From: Zac Denton
Sent: 21 September 2017 11:32
To: [REDACTED]
Cc: [REDACTED]
Subject: RE: R/1/17/T - Trees at Parklands and poplars

I believe that the main source of confusion relates to the numbering system be repeated and not consecutive, please provide plans and schedules that clearly label the trees (as stated in the final sentence of the Arboricultural response.)

BROOKEN BEE

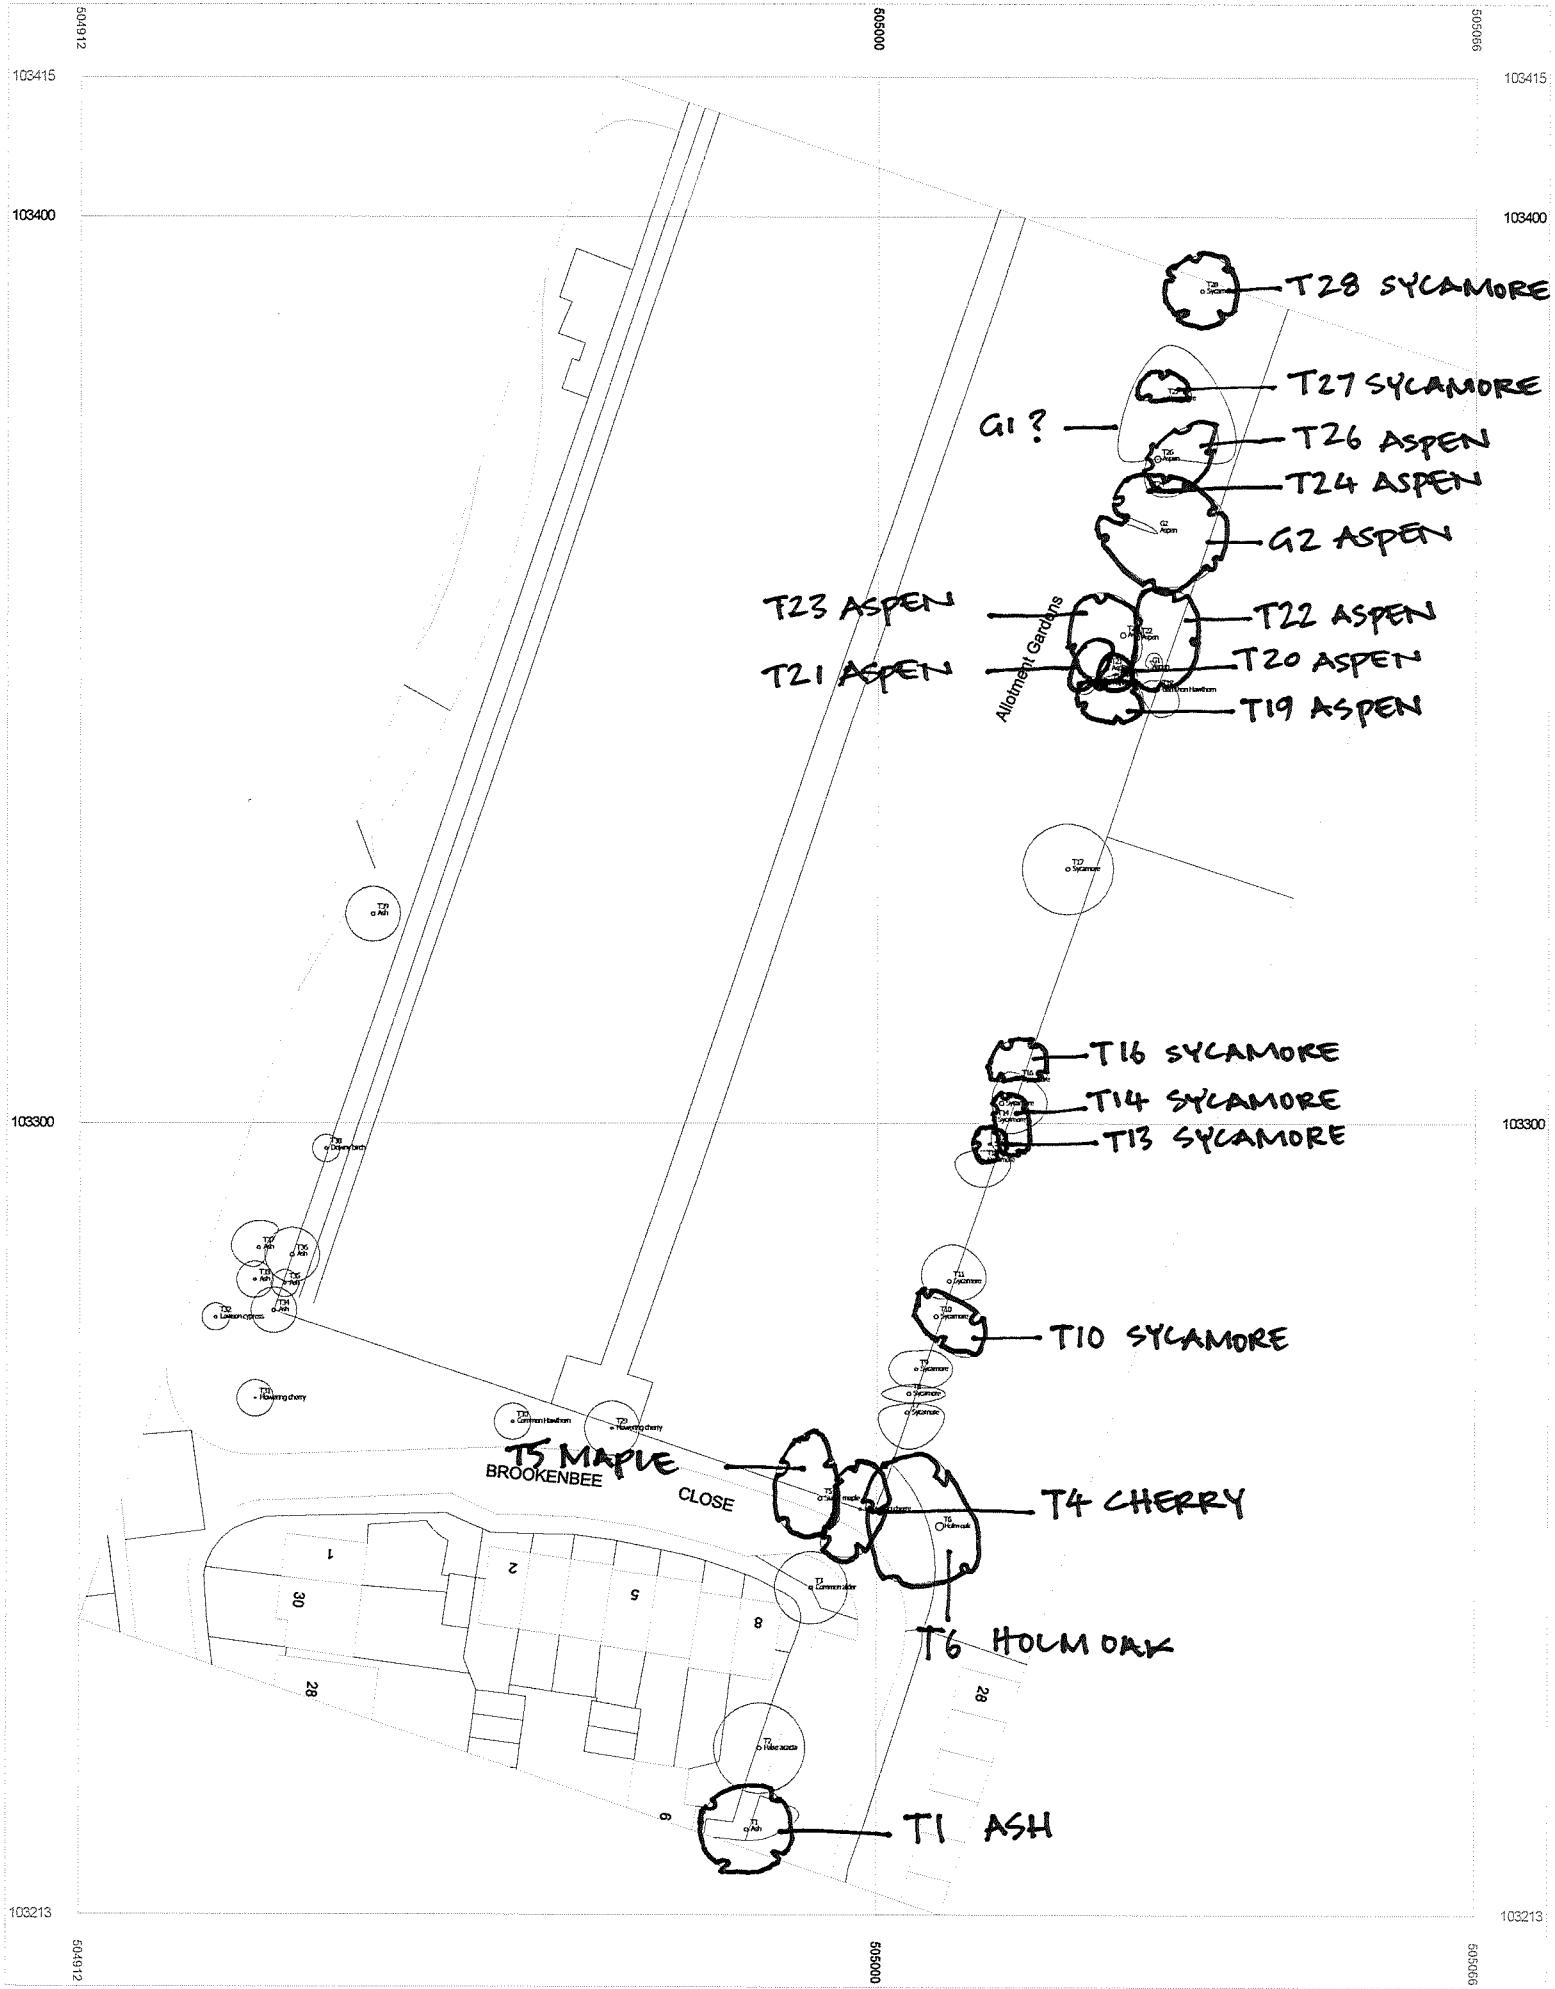
"I have spent some time printing out their survey sheets – only to find that the first two sections going from T1 to T184 & G1 G2 are repeated – then I get T1 to T39 & G1 & G2 – then I get a batch of survey sheets that bear no numbering whatsoever in the left hand side of the sheets and they start with 'height' – NONE of these are labelled as to where on the site they are?

The full site plan prints out as a blurred mess with the grey crownspreads obliterating the numbering!!

Overall I have wasted time on this and until they send it in clearly labelled with the relevant survey sheets clearly attached to a plan that bears the same numbering and can be cross referenced there is no way that I can determine this application!?!"
